Re: Bob's Burger
305 Eubank Blvd. NE
Traffic Circulation Layout
Architect's Stamp 05-17-2022 (D20-D049)

This letter is intended to address the comments submitted to my office on May 23rd, 2022 by Nilo Salgado. Each comment has been addressed independently in order. Adjustments have been made as defined below if necessary. Nilo was consulted on 07.18.2022. His responses are provided in RED. Ernest was consulted on site 08.19.2022. His responses are also provided in RED.

# AS-502

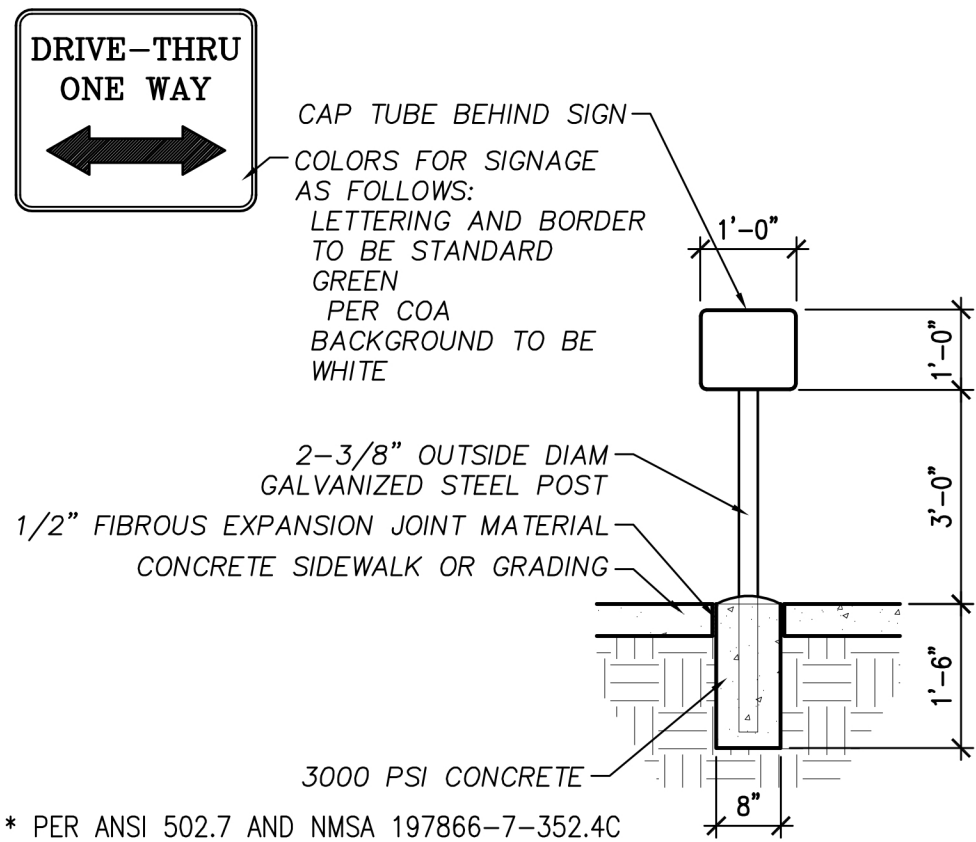
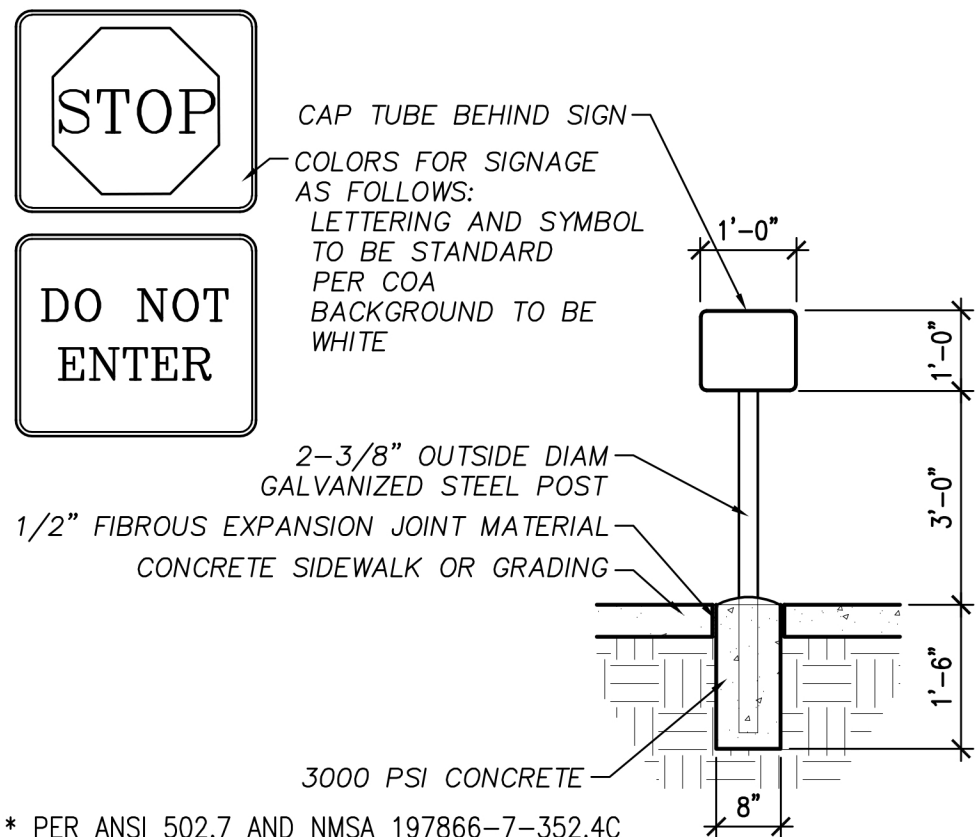
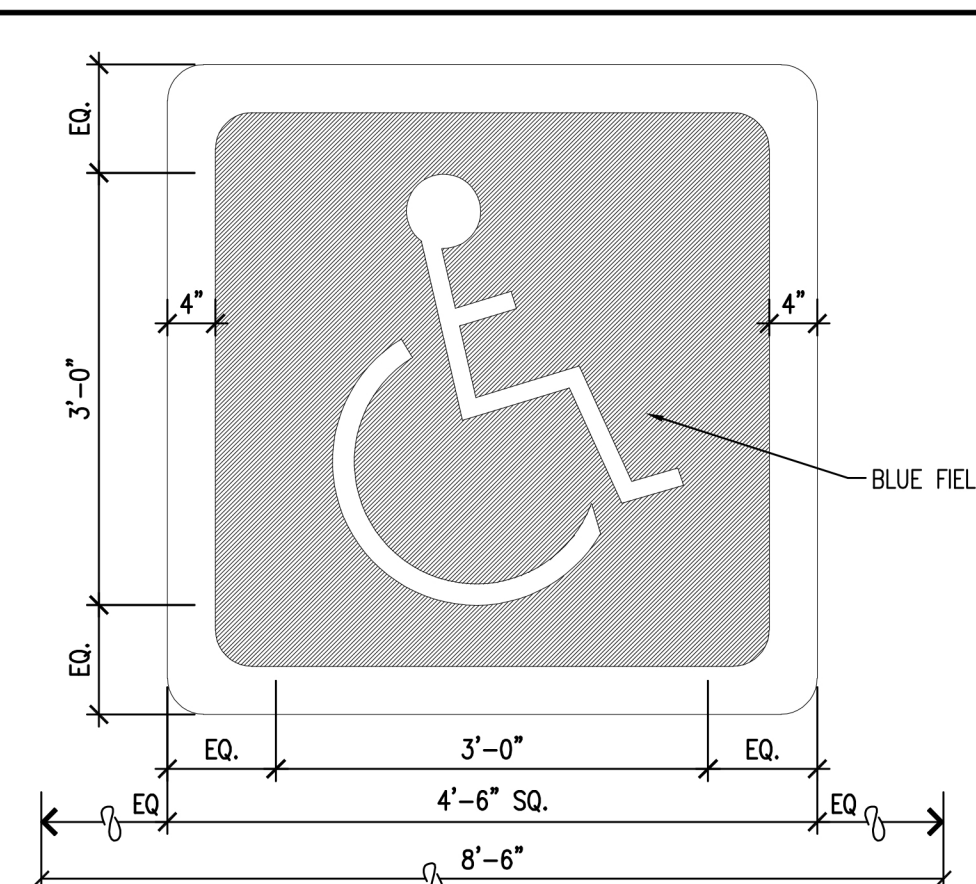
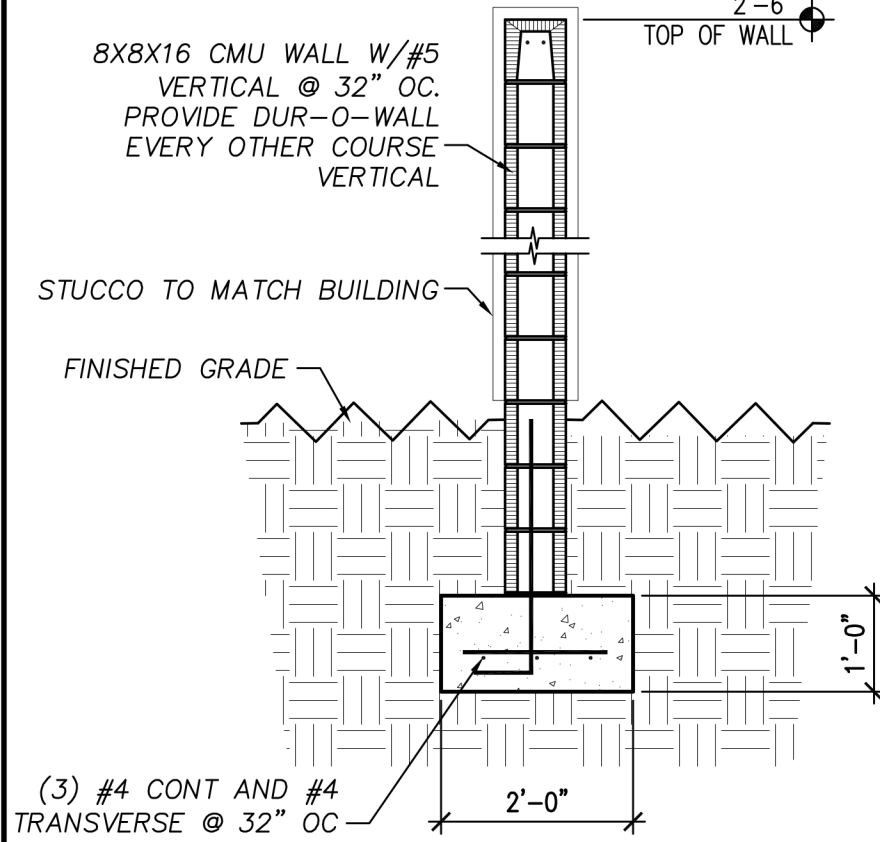
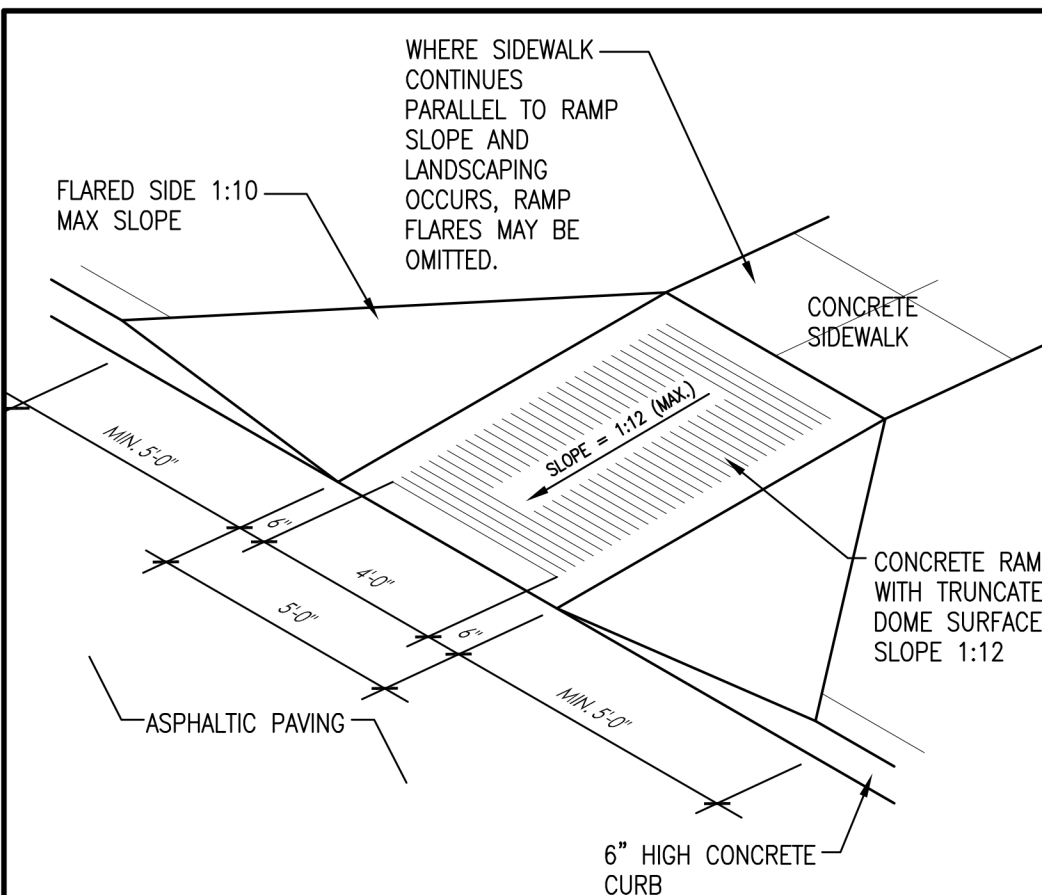
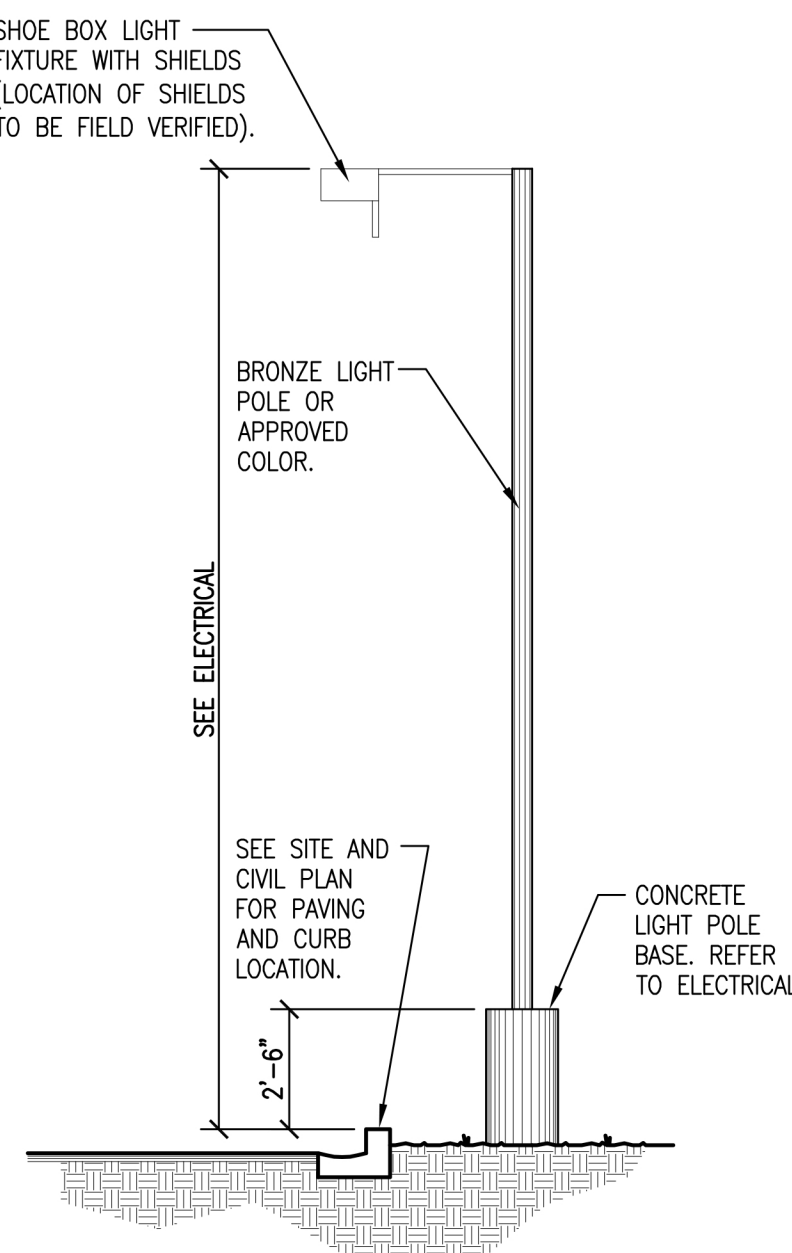
- Provide details for all proposed infrastructure on plans.
- A special detail will be needed for drivepad transitioning from pad to curb returns (from a gutter pan to a 6' valley gutter).
- Locate proposed sidewalk segment to property line and not at back of curb as shown.
- You will need adjacent property owner permission to perform work on his frontage. Provide letter of permission.
- Call out COA std dwg 2430 for Keyed Note 27.

08.19.2022 – MET WITH ERNEST AT THE SITE. HE CONFIRMED AND ACCEPTED OUR RESPONSE. EXISTING CONDITIONS WILL REMAIN ON THE WEST SIDE OF THE DRIVE PAD ENTRY AND WE WILL UPDATE THE EAST SIDE AS PROPOSED. DETAIL HAS BEEN ADDED TO SHEET AS-502. SIDEWALKS WILL REMAIN AS PROPOSED WITHIN THIS TCL SUBMITTAL.
